**KIRKLEES METROPOLITAN COUNCIL  
INVESTMENT & REGENERATION SERVICE**

**DELEGATED DECISION TO DETERMINE PLANNING APPLICATIONS**

Reference No:	<b>2025/62/92591/E</b>
Site Address:	Marsh Farm, Marsh Lane, Shepley, Huddersfield, HD8 8AT
Description:	Change of use and alterations to convert existing storage shed into standalone dwelling for short stay use with associated external works
Recommending Officer:	Elenya Jackson

PROPOSED BLOCK PLAN
1:200

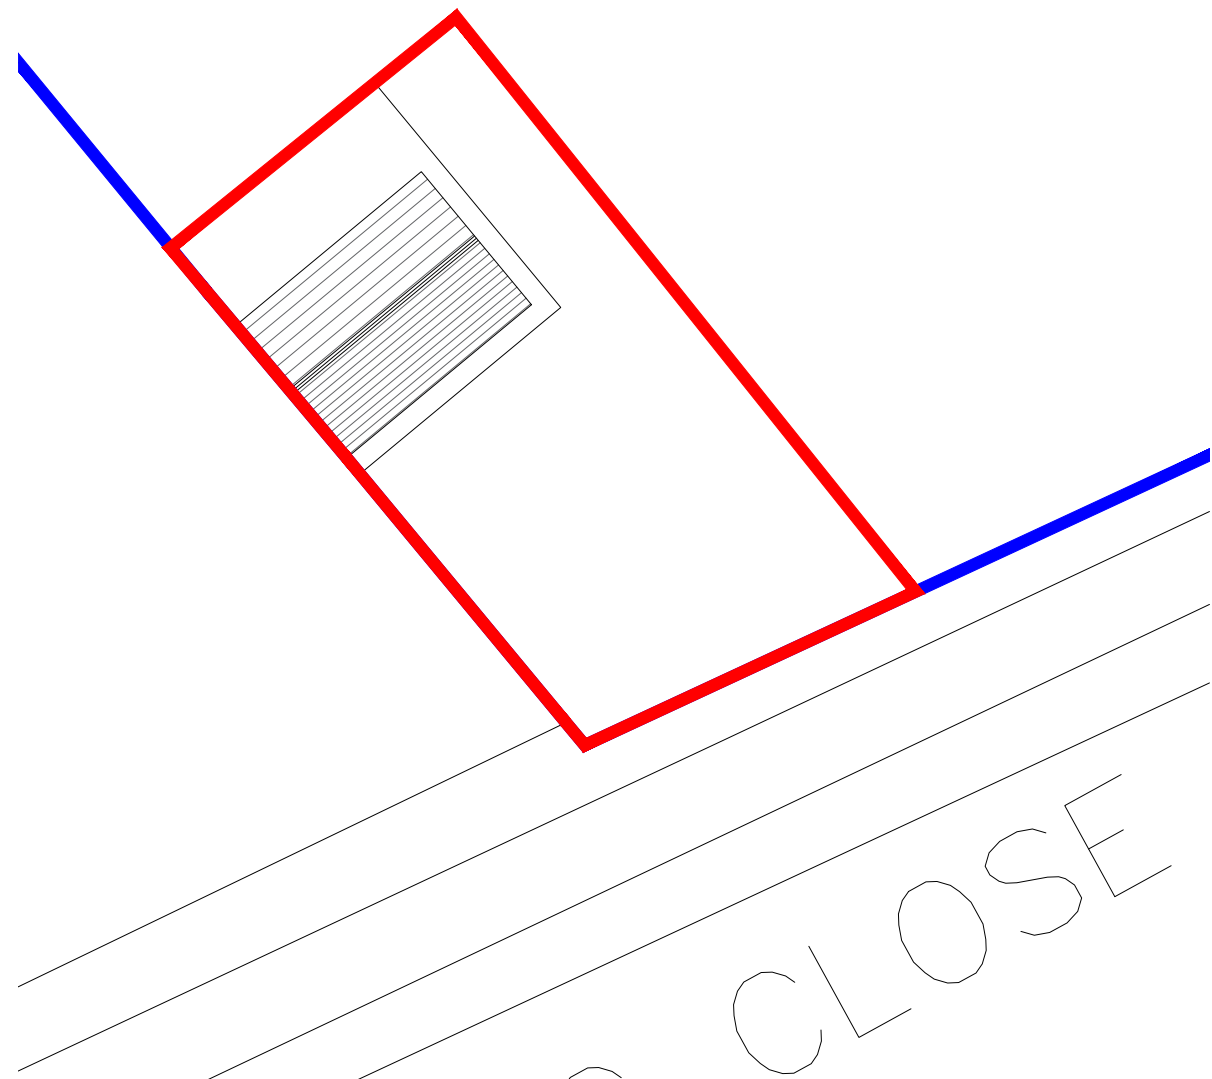
Officers requested clarification on whether or not the proposal would be able to facilitate appropriate parking. Amended plans were provided showing the proposal having one vehicle accessing the site.

The proposal would also introduce grass crete to facilitate a parking area for the development. Officers consider that this would be located in close proximity to a boundary wall and would have limited vantage points in the public realm. The proposed building is not an independent residential dwelling and would not be continually occupied which would lessen the proposals impact.

The proposal has been reviewed with KC Highways Development Management and initially further details were requested relating to waste storage and parking provision.

The applicant has confirmed that one parking space would be provided and waste would be removed via existing contracts associated with the campsite.

Officers requested clarification on waste disposal and vehicular access on site during course of the application. An amended block plan was provided to show parking.
